**CITY OF ALBUQUERQUE
PLANNING DEPARTMENT
November 7, 2012
DRB Comments**

PROJECT # 1005390

APPLICATION # 12-70347

RE: Lot 12-A, NZ Commercial Office Center

SKETCH PLAT OF  
**LOTS 12-A-1 AND 12-A-2**  
**NZ COMMERCIAL -**  
**OFFICE CENTER**  
 CITY OF ALBUQUERQUE  
 BERNALILLO COUNTY, NEW MEXICO  
 NOVEMBER, 2012

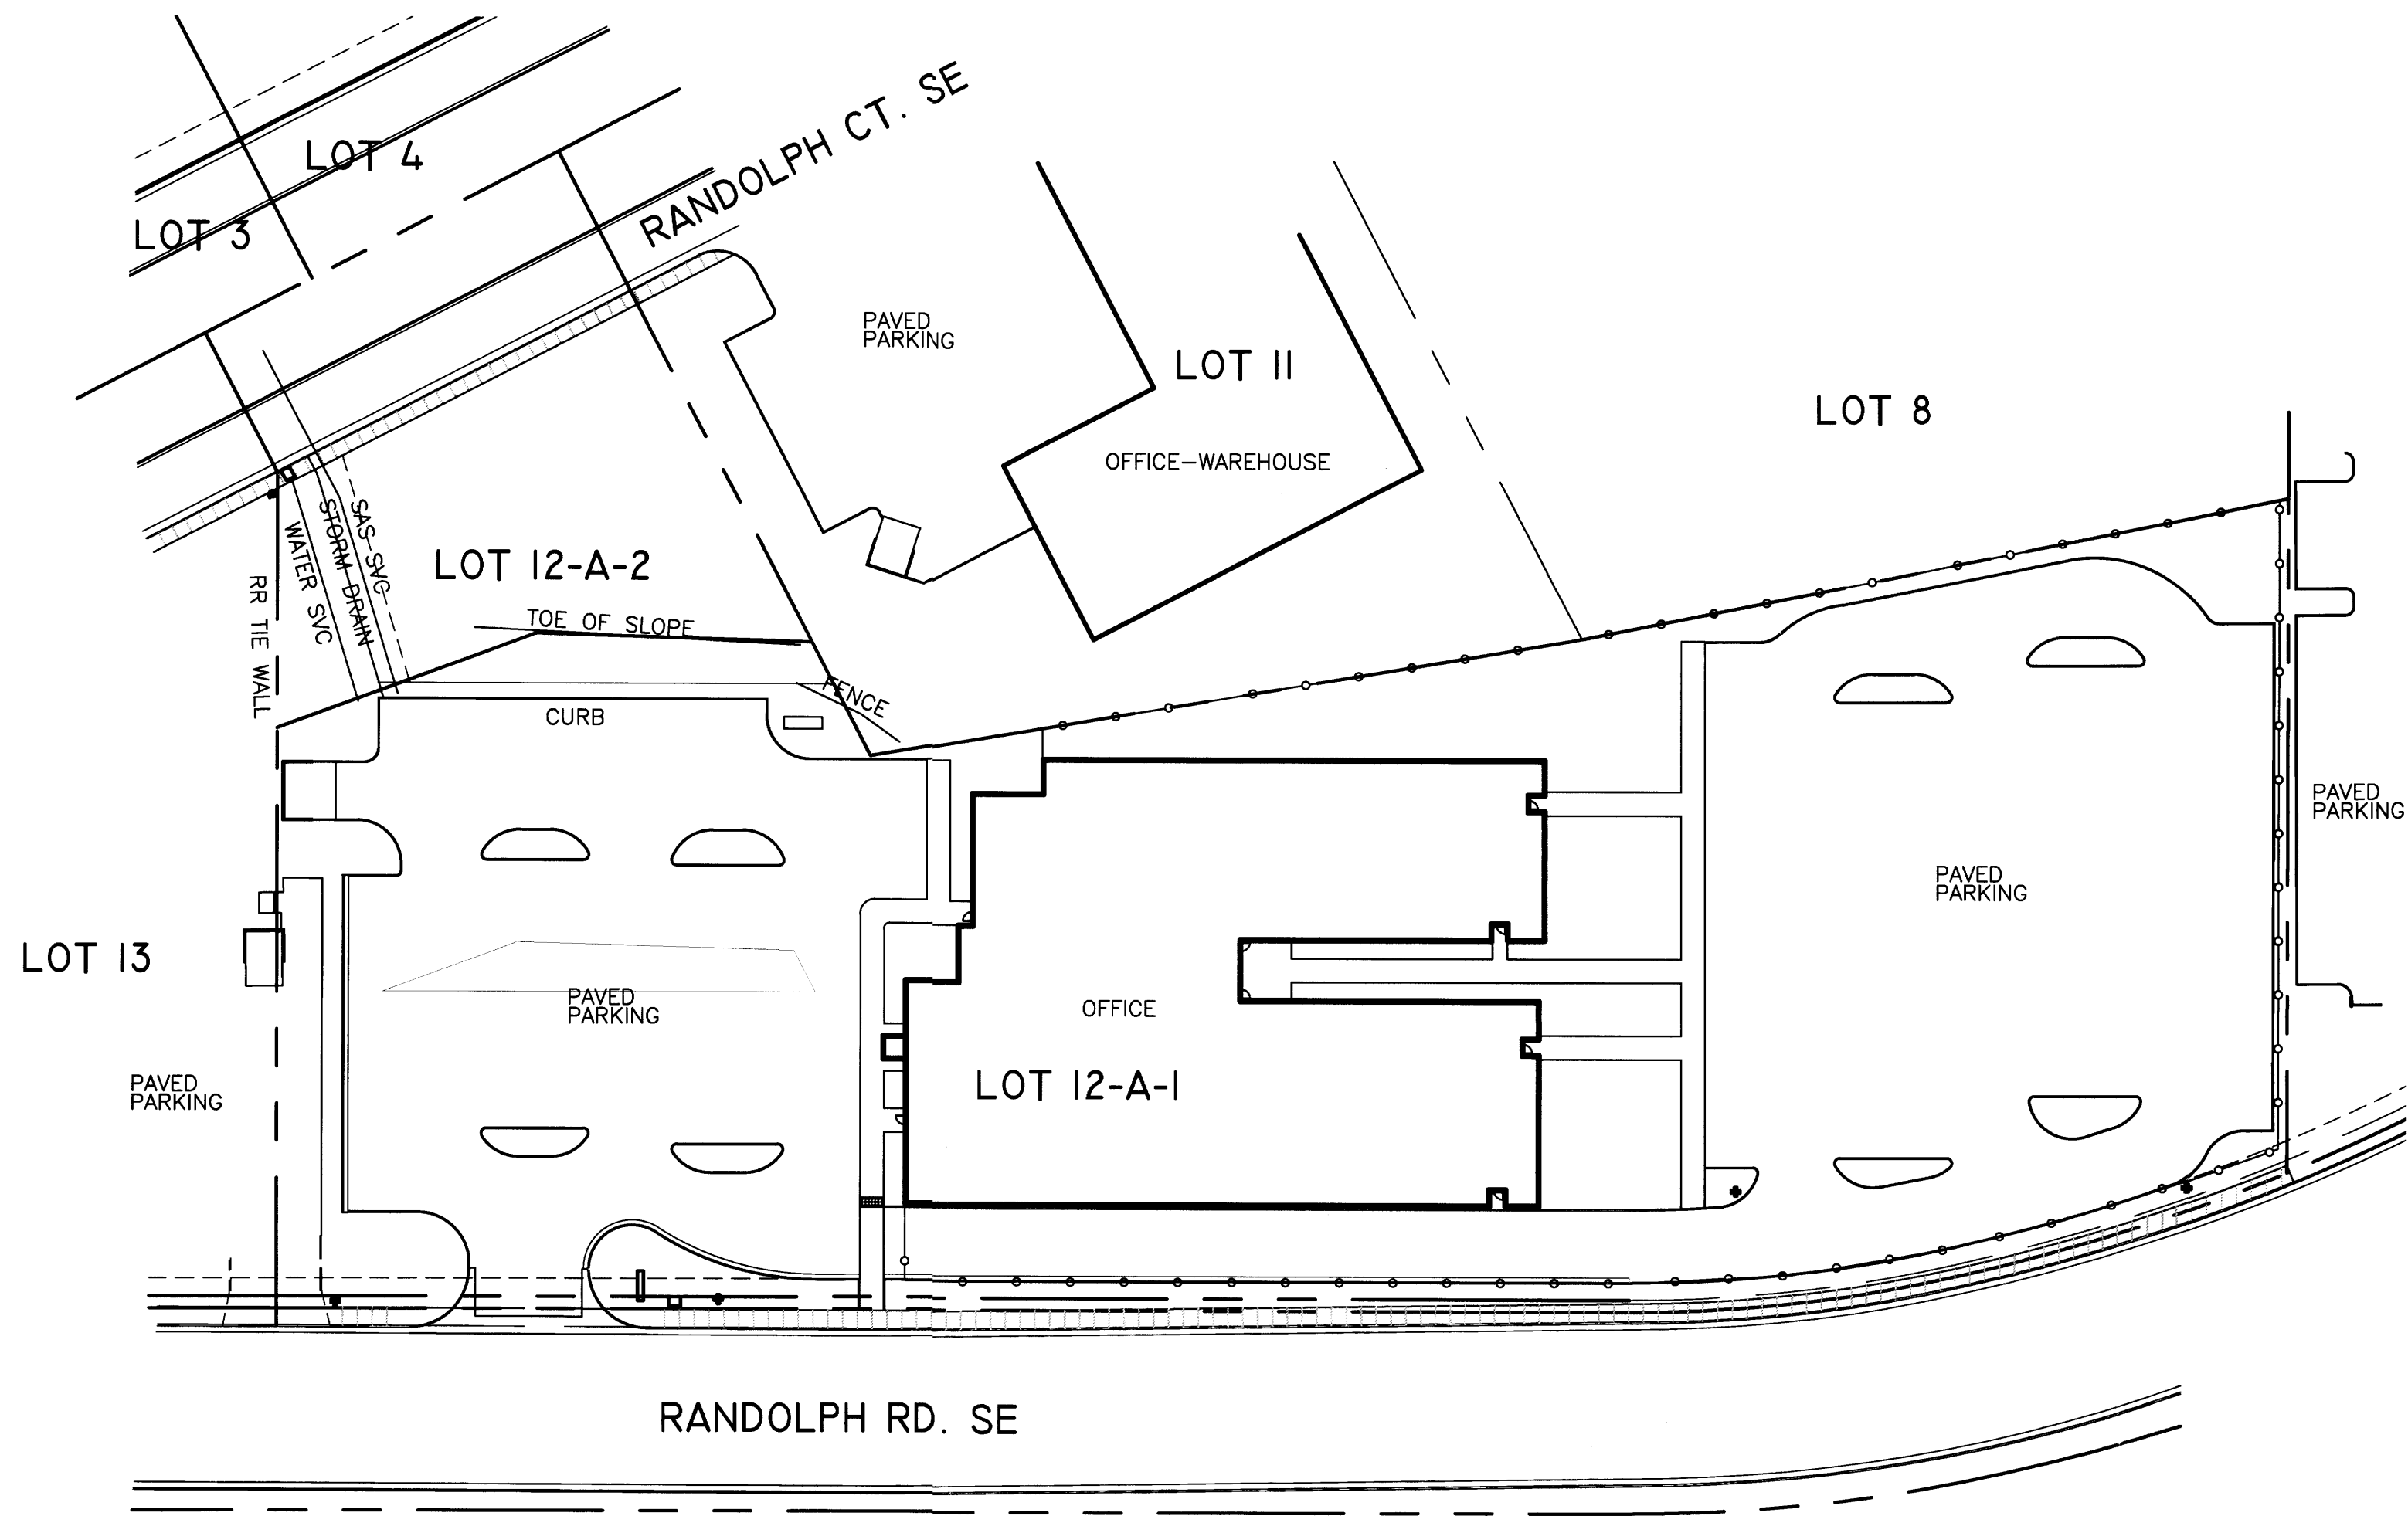
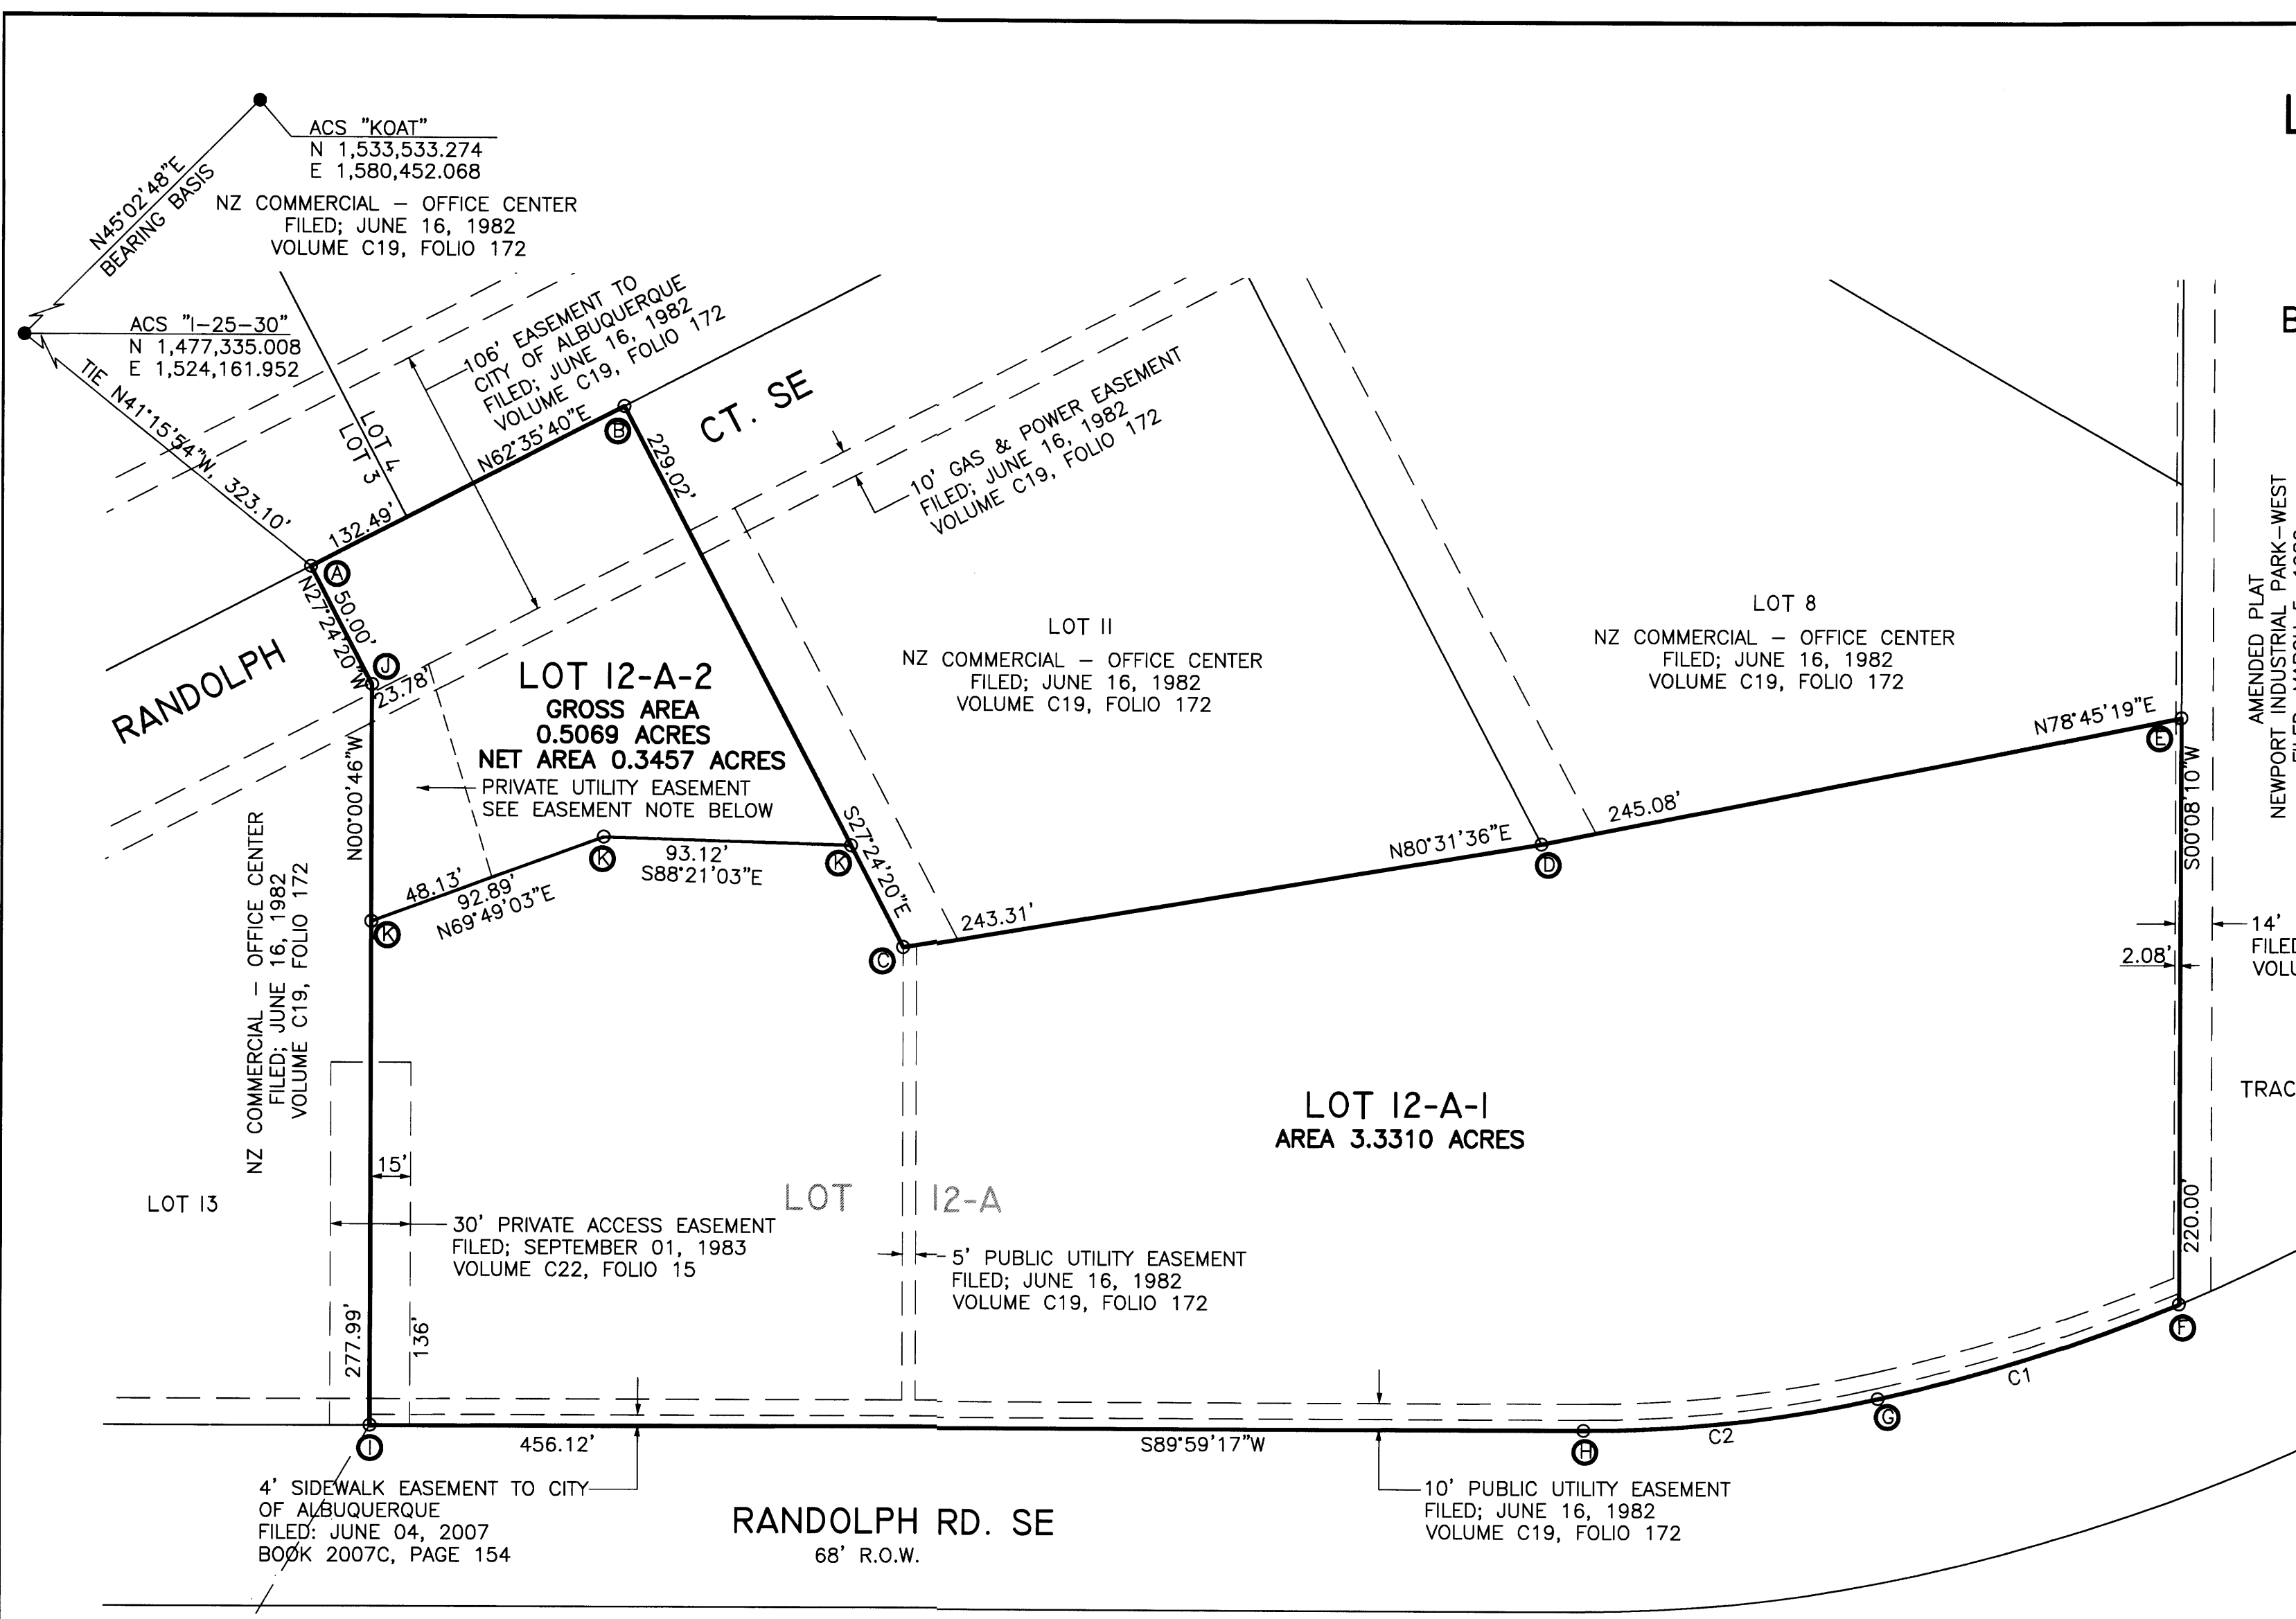
The site is zoned IP; minimum lot area is .5 acre net. Perhaps adjoining property owners would be interested in acquisition of the smaller portion and participation in the replat by combining that portion with their lot(s).
